BENHALL & STERNFIELD PARISH COUNCIL
MRS MELANIE THURSTON – CILCA CLERK TO THE PARISH COUNCIL

Planning Inspectorate EN010012

Re: The Sizewell C Project

Benhall & Sternfield Parish request for additional measures to be incorporated into the Sizewell C DCO, to mitigate against the currently poor design of the Two Village Bypass (TVB) and the effect that it will have on the dwellings near the A12 and those in the Farnham Hall area.

DRAWING TITLE:
TWO VILLAGE BYPASS PROPOSED GENERAL ARRANGEMENT AND PROFILES SHEET 1 OF 2

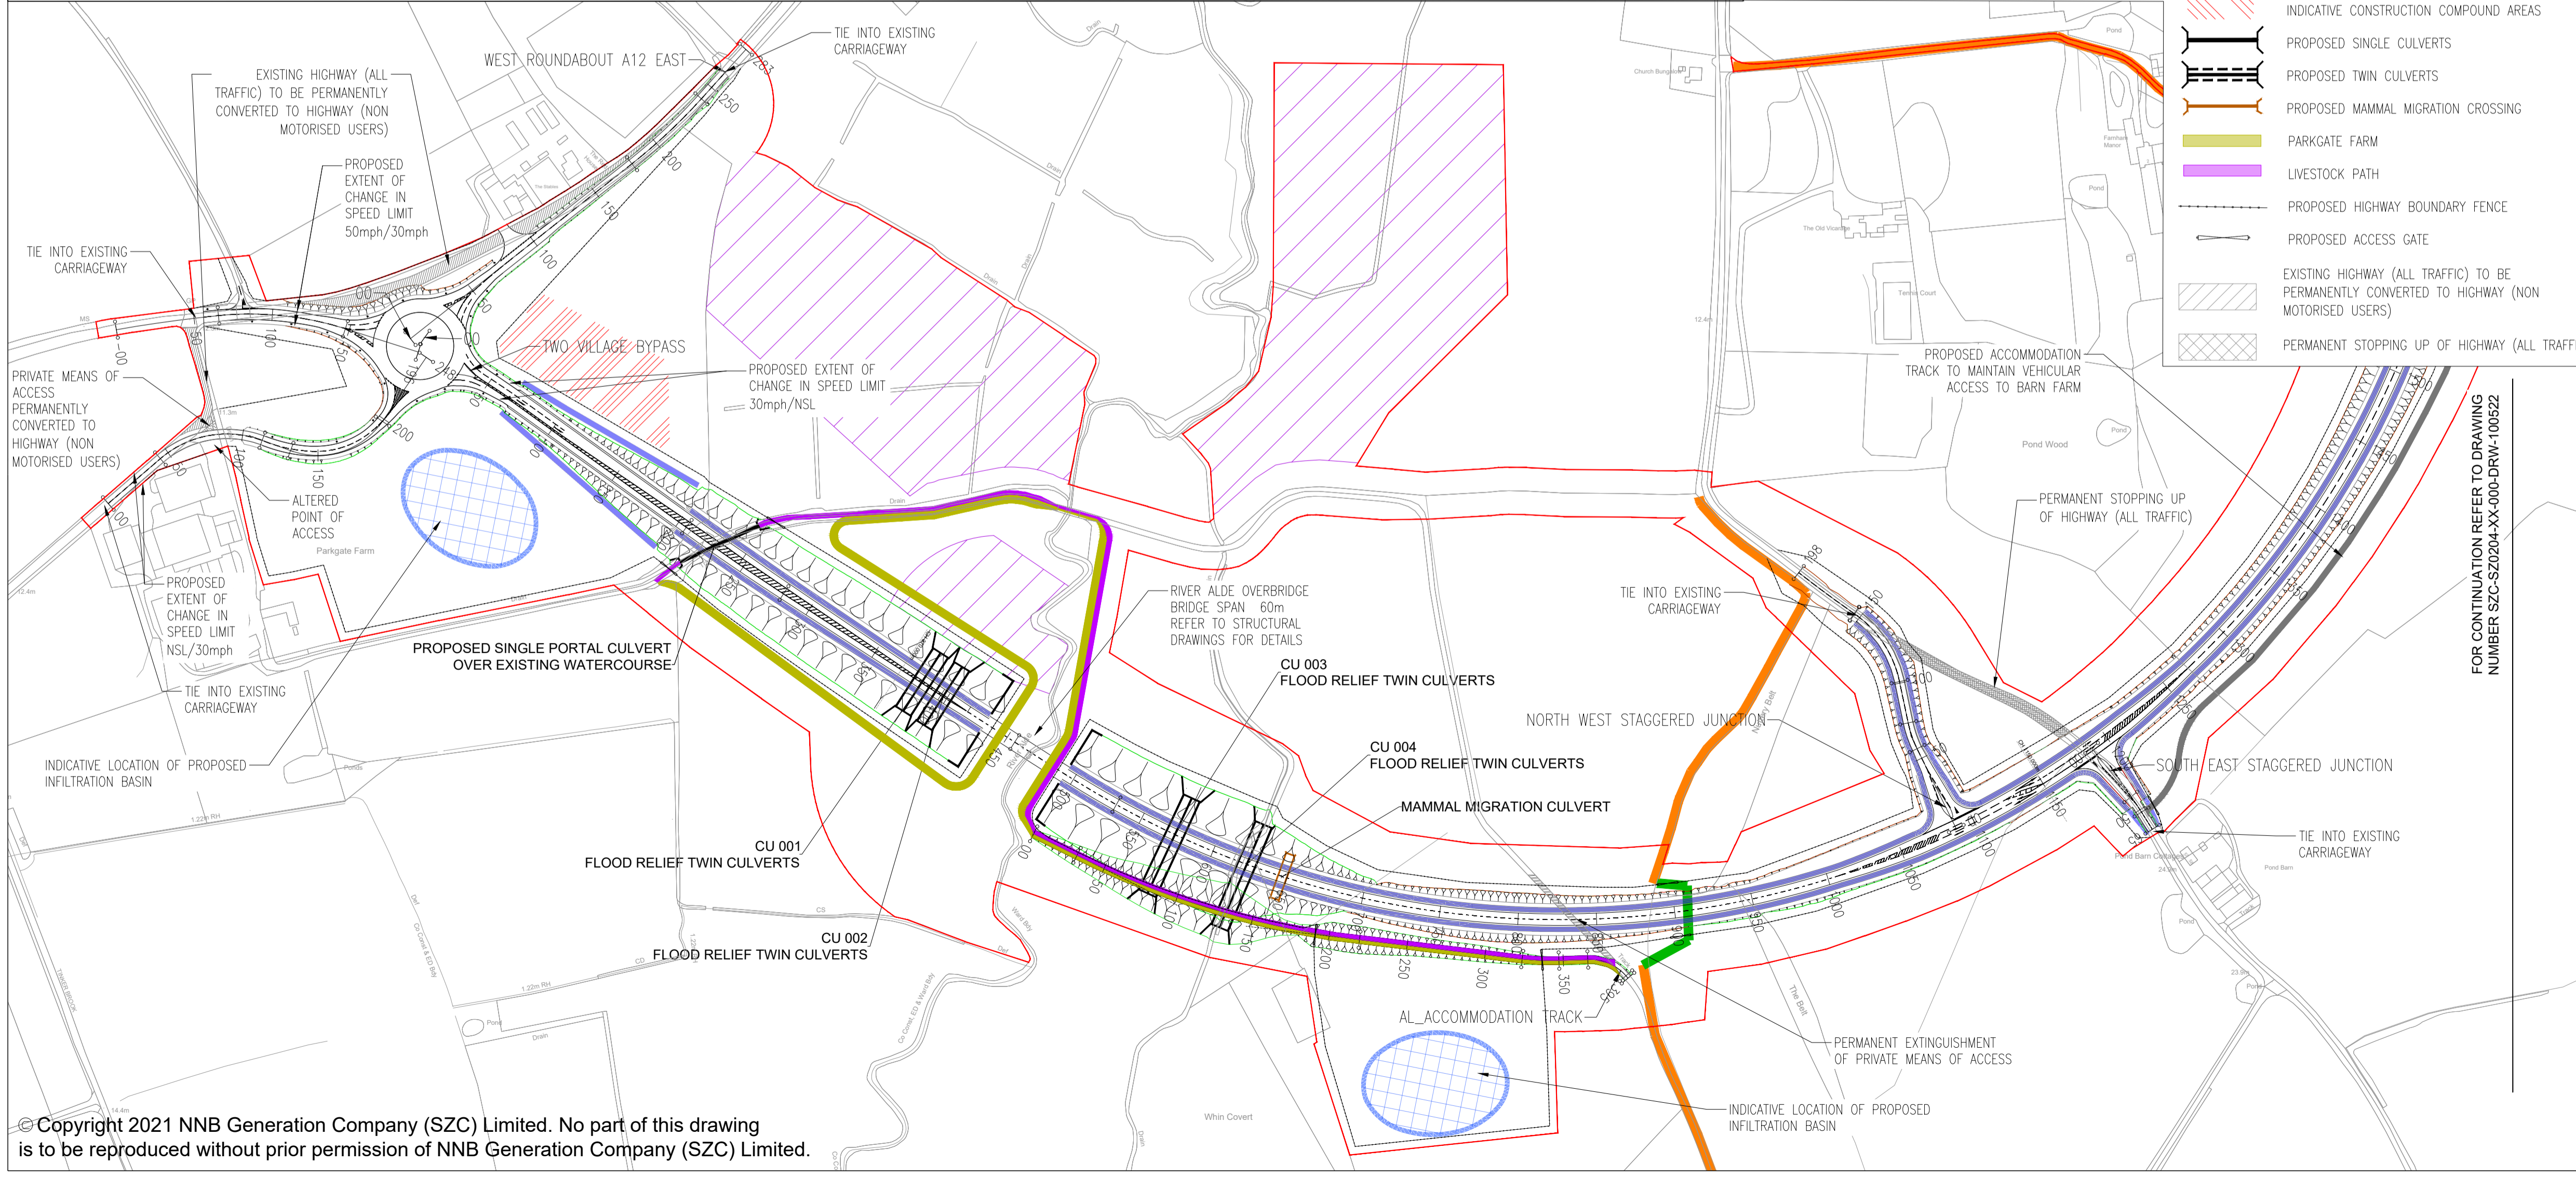
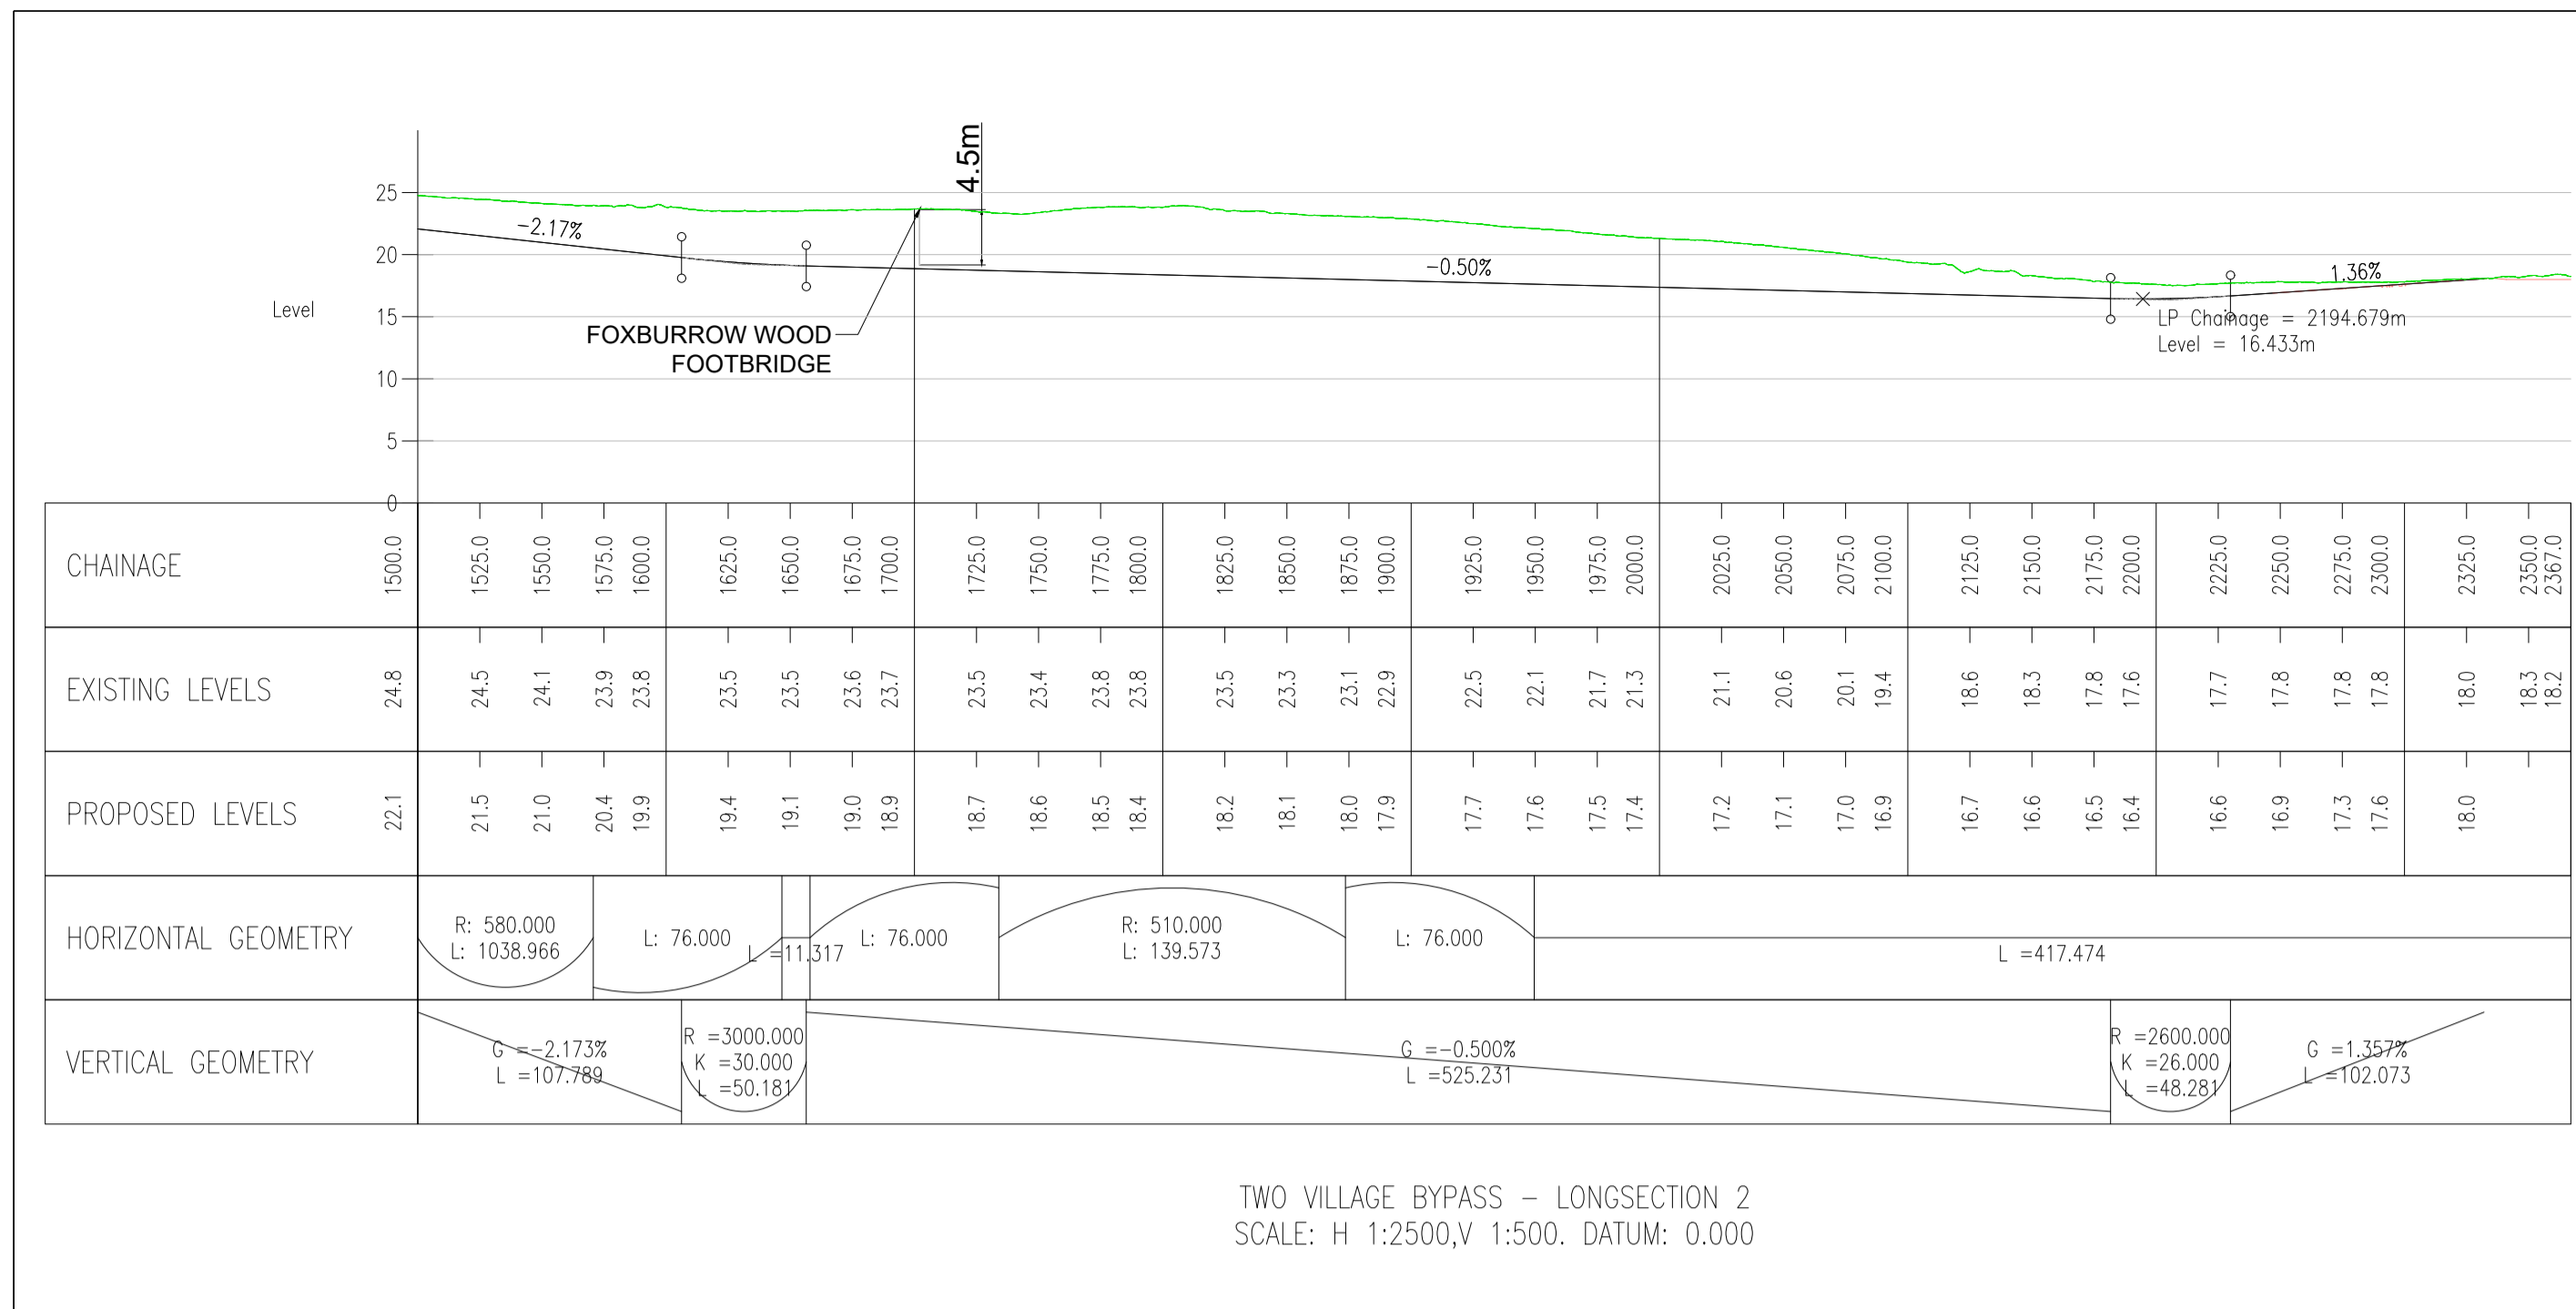
- A bund parallel to the route of the proposed Two Village Bypass to screen business' and parts of property.
- Visual and screening noise attenuation fencing around the eastern construction compound.
- Additional soft and hard landscaping to absorb the bypass into its setting.

Aside from the proximity of the TVB to the neighbouring properties and business', the most significant issue faced is the noise that the bypass will create – both during construction and in-life. The temporary construction area abuts Molletts Farm and is immediately adjacent to the two Benhall Stock Cottages and the Old Police House. Since even EDF admits their TVB scheme will cause irreversible harm to the tranquillity of this setting, we are keen to ensure that they take every possible step to minimise those effects.

We therefore ask for a better TVB design that includes noise-mitigating bunding along the western edge of the northern section (between Friday Street and the Farnham Hall area), low-noise road surfacing in the same zone and safe pedestrian crossings for all four arms of the Friday Street roundabout. We believe that, taken together, these measures will be of significant benefit to all those concerned – which amounts to 17 residential dwellings, Molletts Farm - tourism-led business (which hosts over 1,000 guests a year and contributes to the local economy) and those that live and enjoy walking around the local area.
